To: All Staff
From: Environmental Health
Date: 6/25/2026
Subject: BL-26-00007 Flying A Land LLC

TO: All Staff
FROM: Public Works Plan Review Team
DATE: June 26, 2026
SUBJECT: BL-26-00007 Flying A Land LLC

RECORD OF SURVEY
 A PORTION OF THE NW 1/4 OF SECTION 32,
 TOWNSHIP 18 NORTH, RANGE 19 EAST, W.M., KITTITAS COUNTY, WASHINGTON

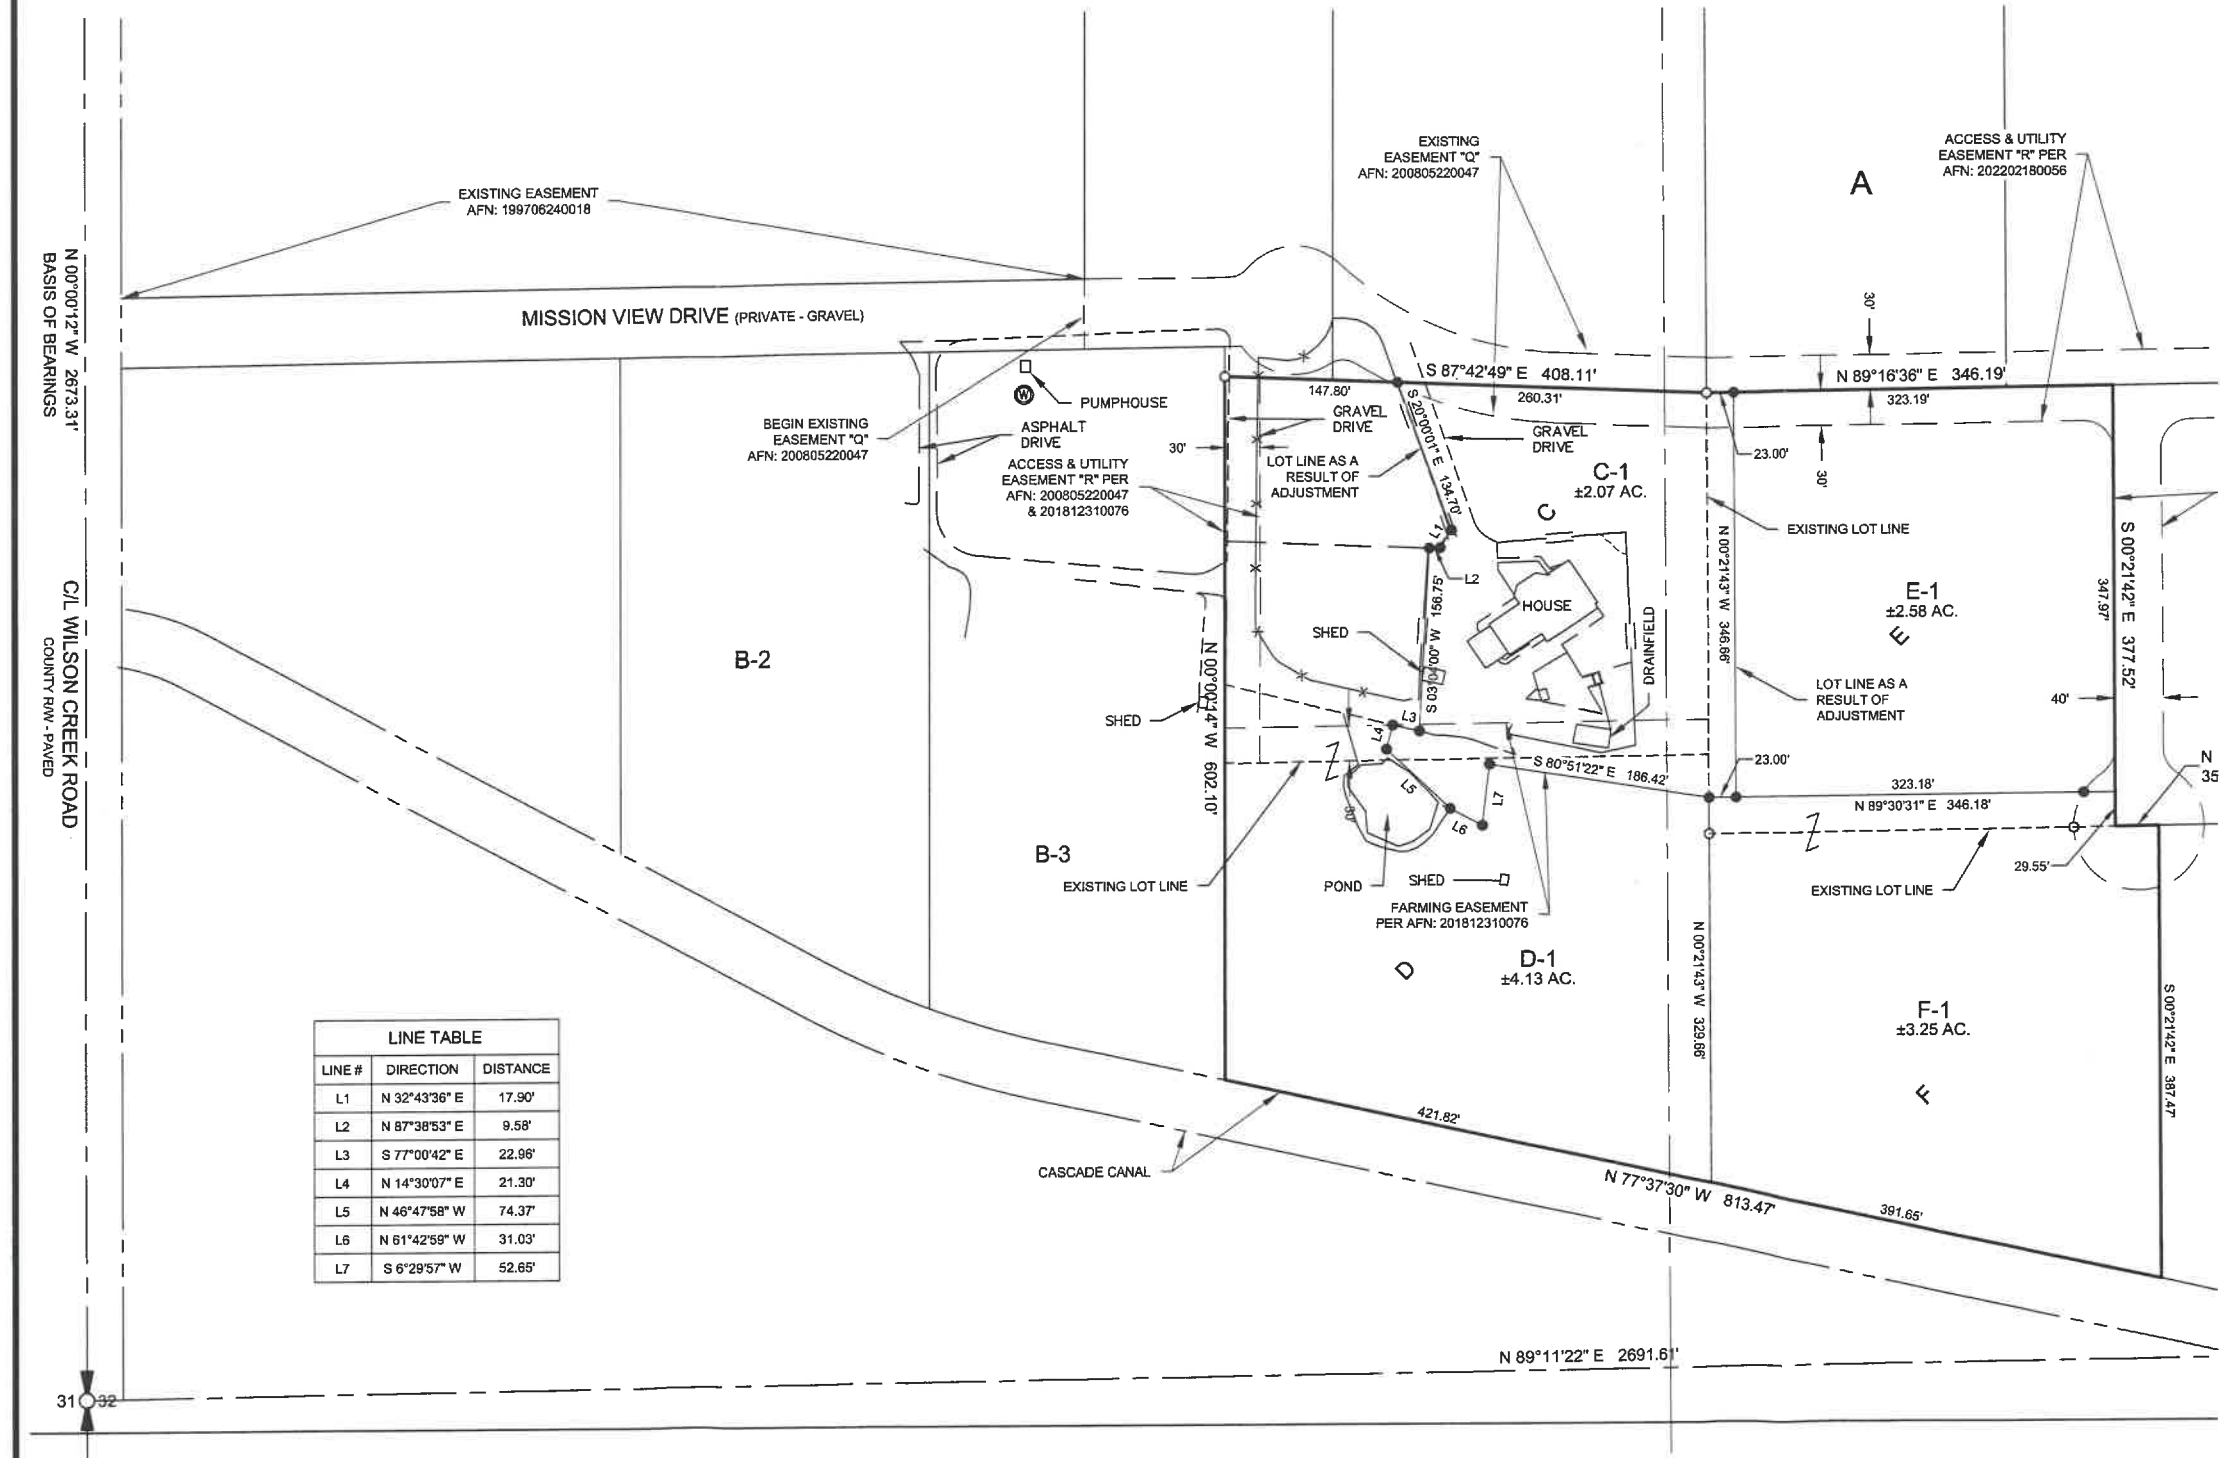
SURVEY	1. Please Show R/W width for Wilson Creek Road, Mission View Drive and Cascade Canal. 2. The Basis of Bearing shown has no ties to the survey of the subject parcel. 3. There are insufficient ties to existing Survey control. 4. Please include description of Section corner shown (Found? Set? Calc?). 5. For existing lots, please include recording information (EX: B-2, SP:E-170 OR Bk: E Short Plats, Pg:170 OR AFN:199706240018) 6. The map is missing a Legend. 7. There are labels that have been cut off to the East of Lot E-1. 8. Some dimensions have been obscured by crossing linework. 9. If any of the property corners shown were utilized as survey control, there should be distance ties to them. 10. The map is missing an Equipment and Procedures Note. 11. The map is missing a Purpose of Survey Note. 12. Closures were not provided with the application. Closures will need to be reviewed prior to final approval. This may result in additional required changes. (JT)
